From: Anita Gardner
Sent: 26 May 2021 17:17
To: Jennen Kinchington [REDACTED]
Subject: FW: LU/287/17/PL 46a - 47 Pier Road Littlehampton

Southern Water have responded to say they cannot recommend discharge of condition 8 relating to surface water drainage.

P5	NOTE 17 ADDED AND KEY UPDATED.	20.05.21	MGC
P4	AMENDED TO SUIT SOUTHERN WATER COMMENTS	22.02.21	MGC
P3	DRAINAGE AMENDED TO SUIT LLFA COMMENTS	15.01.21	MGC
P2	MANHOLE SCHEDULES ADDED	10.12.19	MGC
P1	PRELIMINARY ISSUE	04.12.19	MGC
REV	AMENDMENT	DATE	CHKD

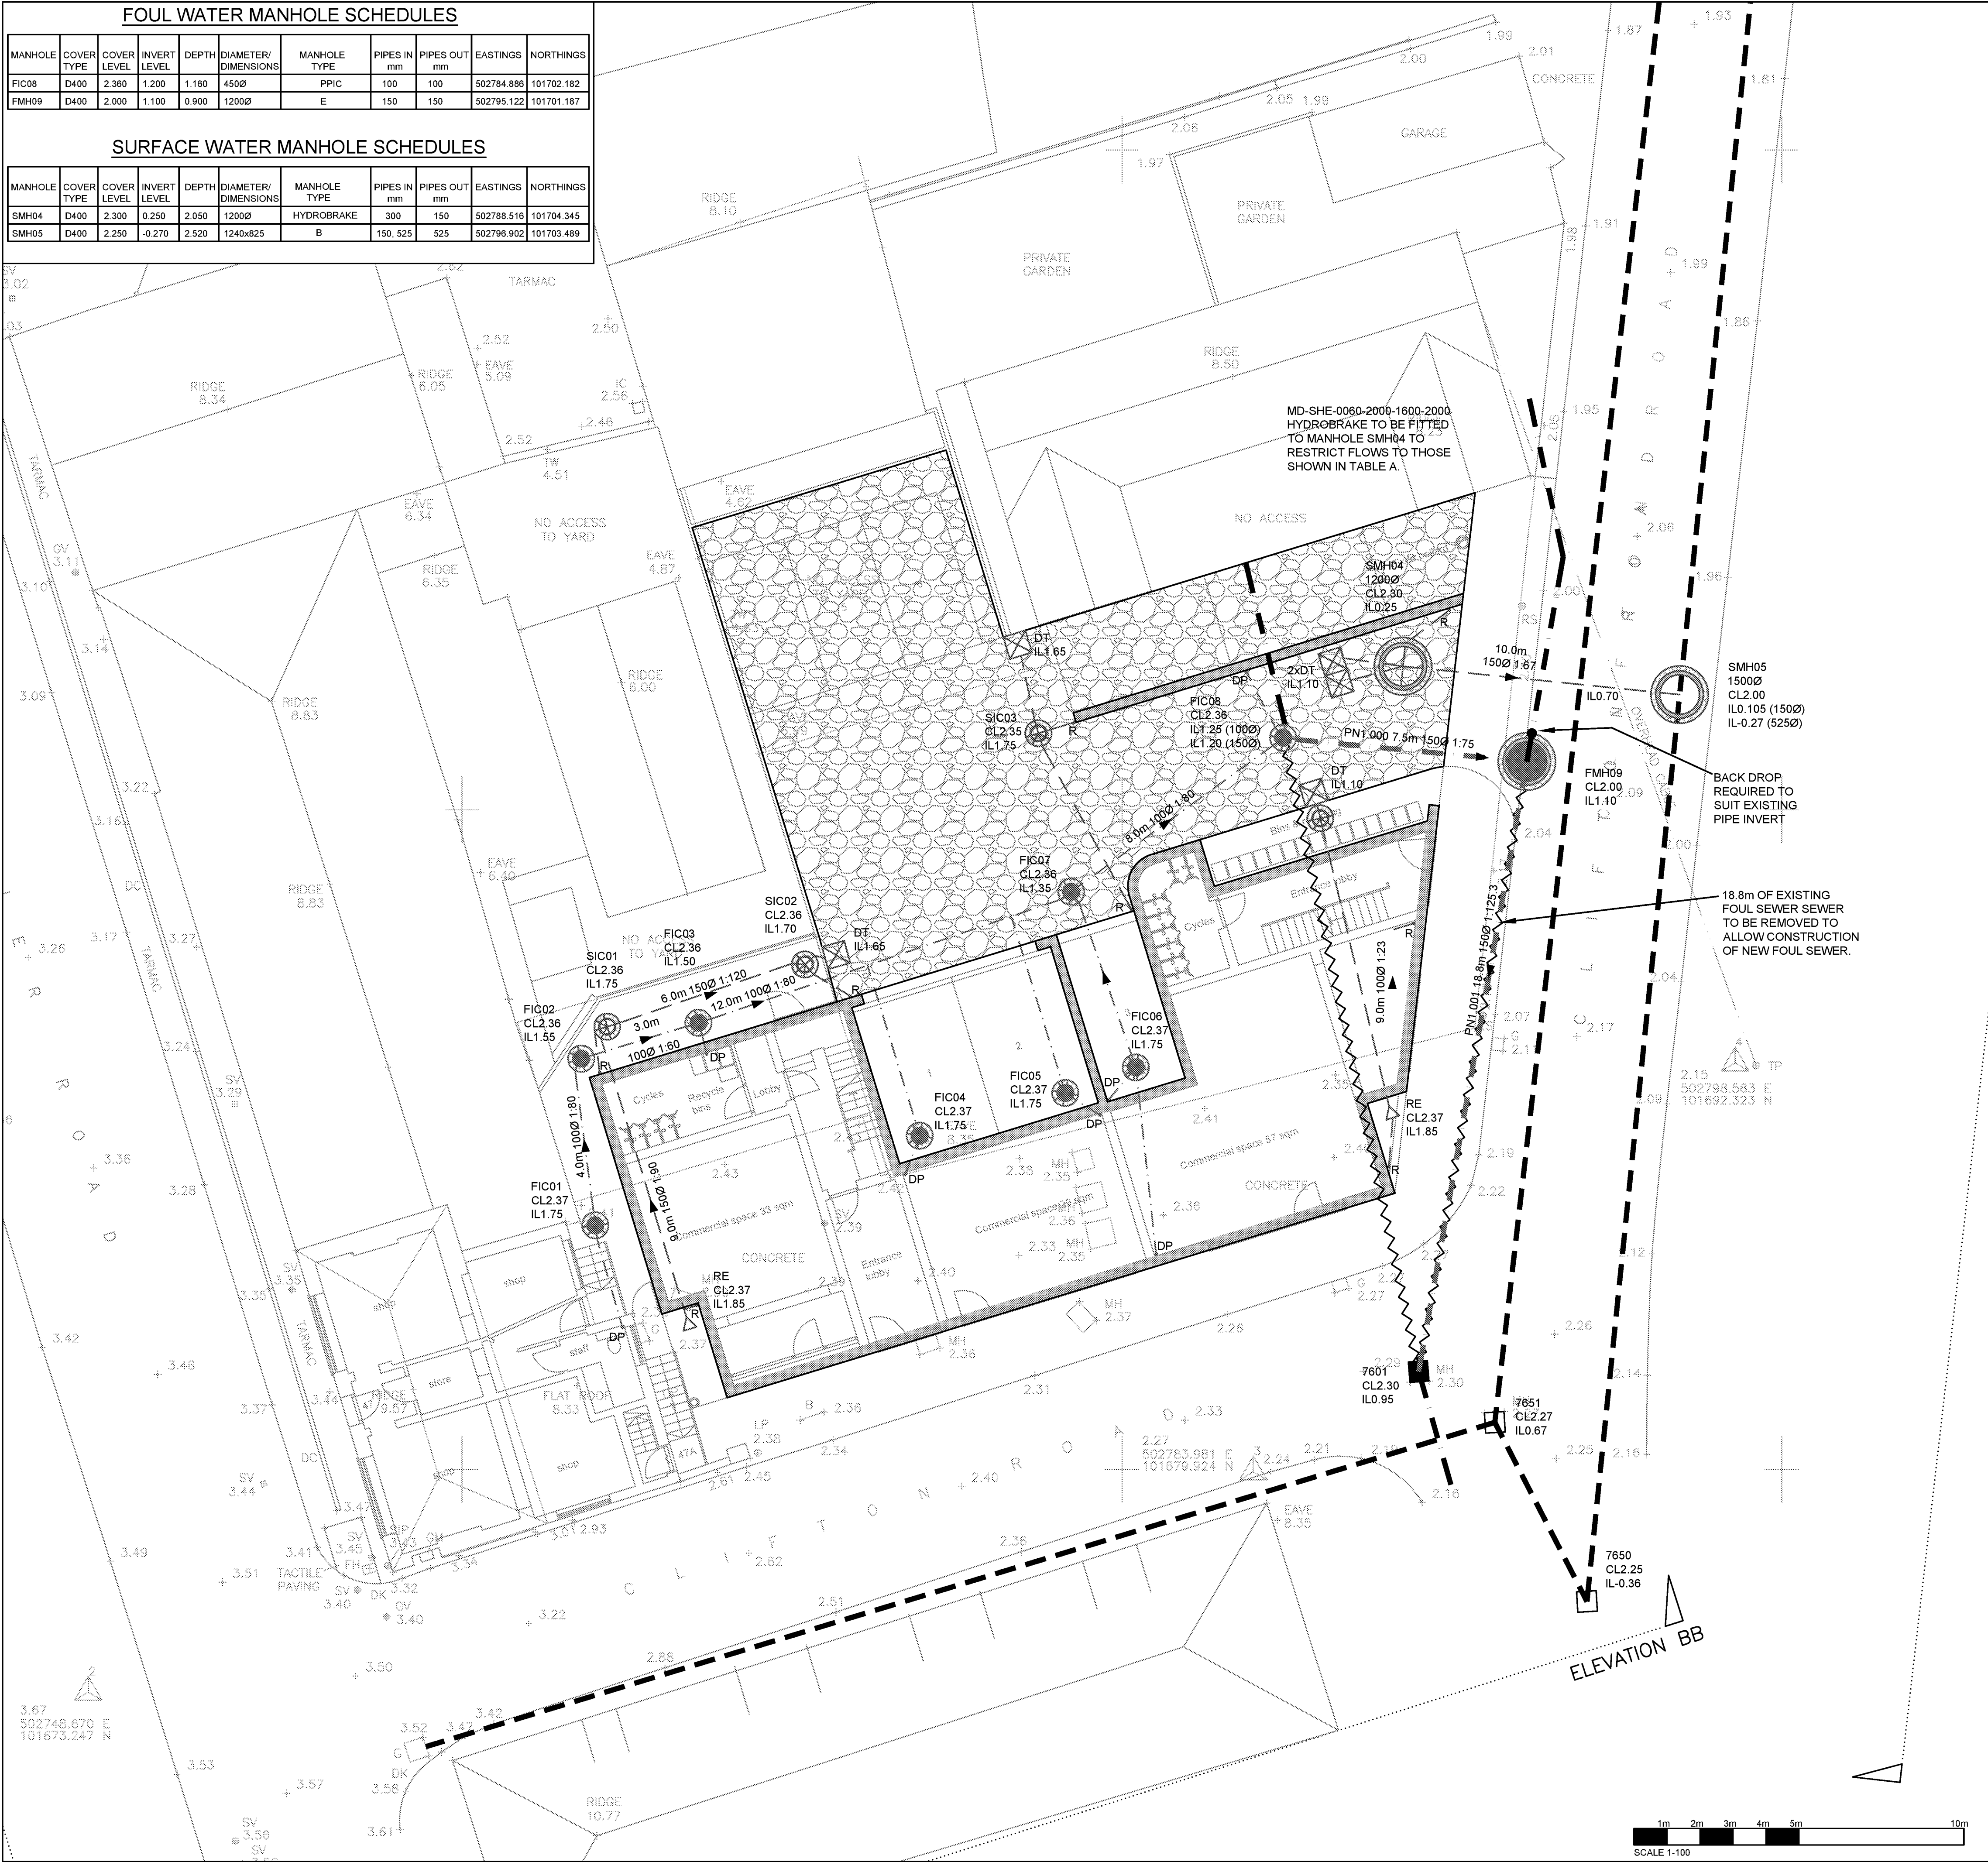
They state 'Drainage from the attenuation tank is communicating to the Southern Water public sewerage systems. Please note Attenuation tank should be sealed with impermeable membrane to avoid ingress of ground water. The design of drainage should ensure that no land drainage or groundwater is to enter public sewers network.'

The drainage strategy report demonstrates that the post development surface water flows from the development are reduced from the current flow contributions. Surface water may be discharged to the existing sewer, provided the rate of discharge to sewer is no greater than existing contributing flows.'

Please find attached the amended drawings showing that an impermeable membrane will be constructed at the base of the sub-base storage system to prevent the migration of ground water into the Southern Water sewer. In any event this will be unlikely as the soils are of clay content with poor infiltration characteristics.

As you can see from table A on drawing 10 the post-development flow rates are significantly lower than pre-development so all the boxes are now ticked.
